REPORT UPDATE

Application No: BE/137/19/RES

Recommendation Report for Approval of Reserved Matters Following Outline Approval

PROPOSAL: Application for approval of phase 2 reserved matters following outline permission BE/63/17/OUT (as amended by BE/131/18/PL) for 20 No. dwellings.

6.04 Plot 11 and 16

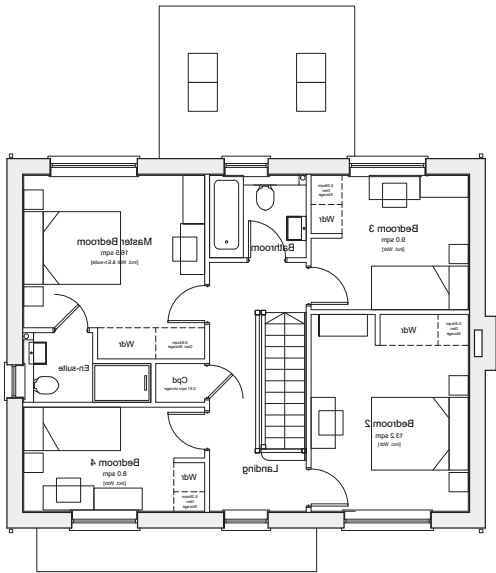
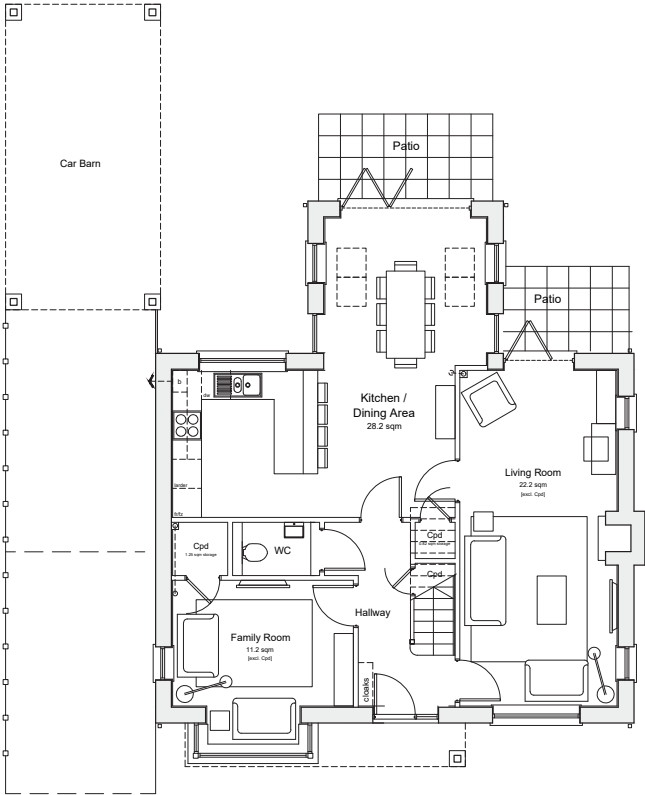
The Councils Tree Officer has stated that his earlier concerns regarding the layout and Root Protection Area (RPA) incursion at plots 01-06, 11 & 16 have now been resolved. The Tree Officer still has concerns with the lack of an approved surface water strategy, the impact of proposed foul water drains on RPA's of retained trees and the impact of the new frontage footway on the off-site T35 Sycamore.

ADC TREE OFFICER - Initially objected on the grounds that the layout differed from that shown at the outline stage with greater Root Protection Area (RPA) incursion at plots 01-06, 11 & 16 and that this is unacceptable. Also considered the T33 Sycamore at plot 16 to have future pressure exerted on it for pruning/felling which will diminish its landscape contribution. Concerned with impact of the frontage footpath on T35 (TPO Sycamore). Noted lack of an agreed drainage scheme and consider this and the proposed foul sewer drains could result in further impacts.

The proposal is subject to an objection from the Tree Officer. The layout has been amended to ensure all of the dwellings are no further into the Root Protection Areas of existing trees than was shown by the indicative layout on the Outline permission. The Tree Officer has advised that on this basis, the proposal is supportable but his formal comments on the latest drawing and supporting documents will be reported at or before the Committee Meeting.

6.06 Plot 17-20

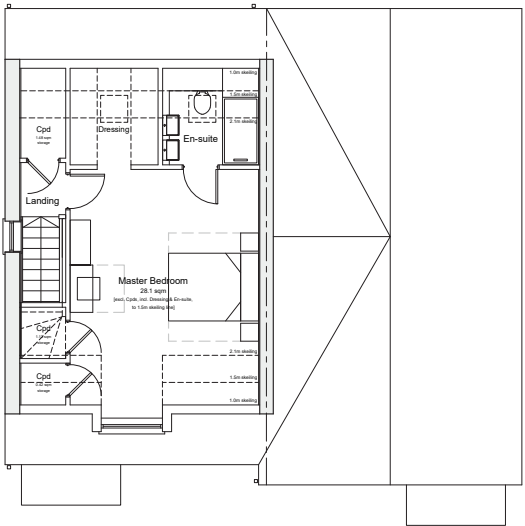
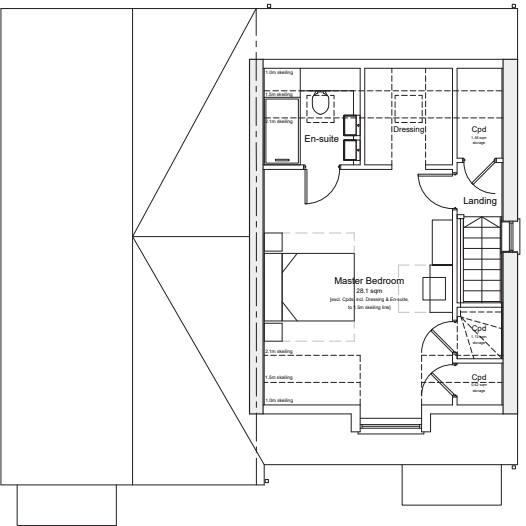
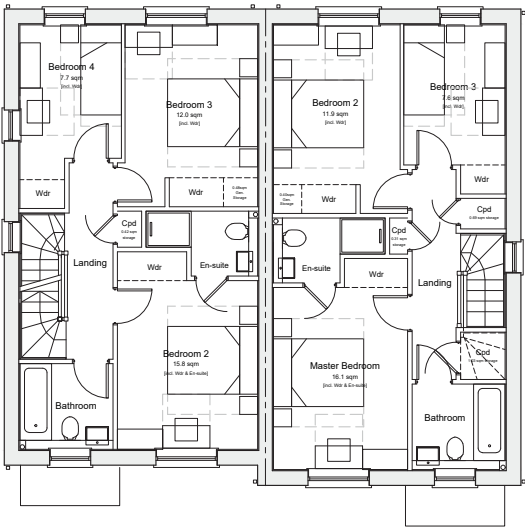
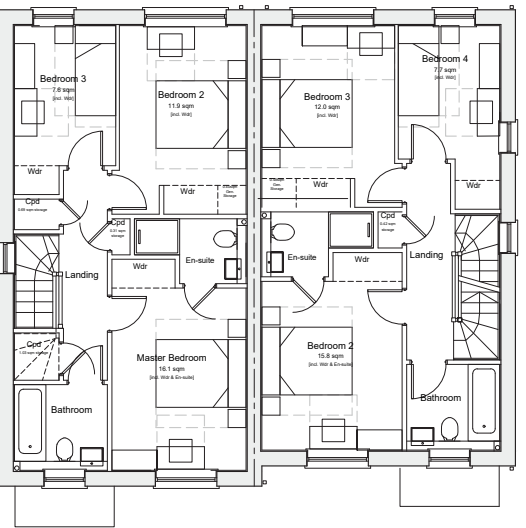
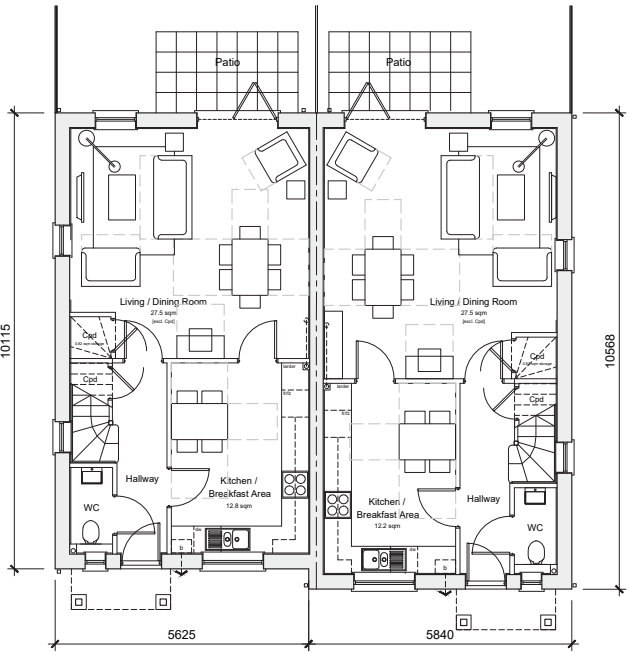
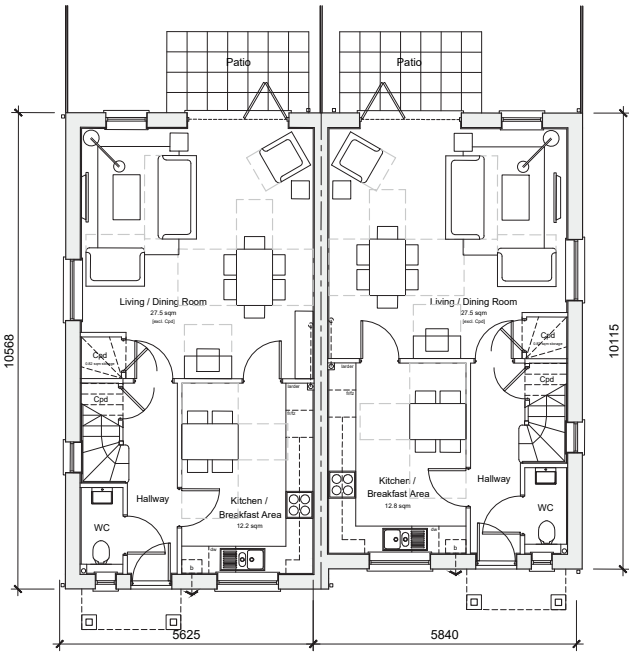
In response to changes to the plans, the Parish state that they still object because although the 2.5 storey houses have changed from 4 to 3 bed, the amended drawings do not show a change in height, just the lack of velux windows from the original. They also consider that the developers should adhere to the recommendations made by the ADC Drainage Engineer.

There were concerns with visitor parking in that spaces adjacent to plot 20 may be more appealing to

owners of plots 17-20 than the car ports at the rear of their gardens. The applicant amended the plans to show secure rear doors in car ports to enable easy access between the house and car. It is considered residents will prefer to park in the car ports where cars will be protected from the elements and from accidental damage.
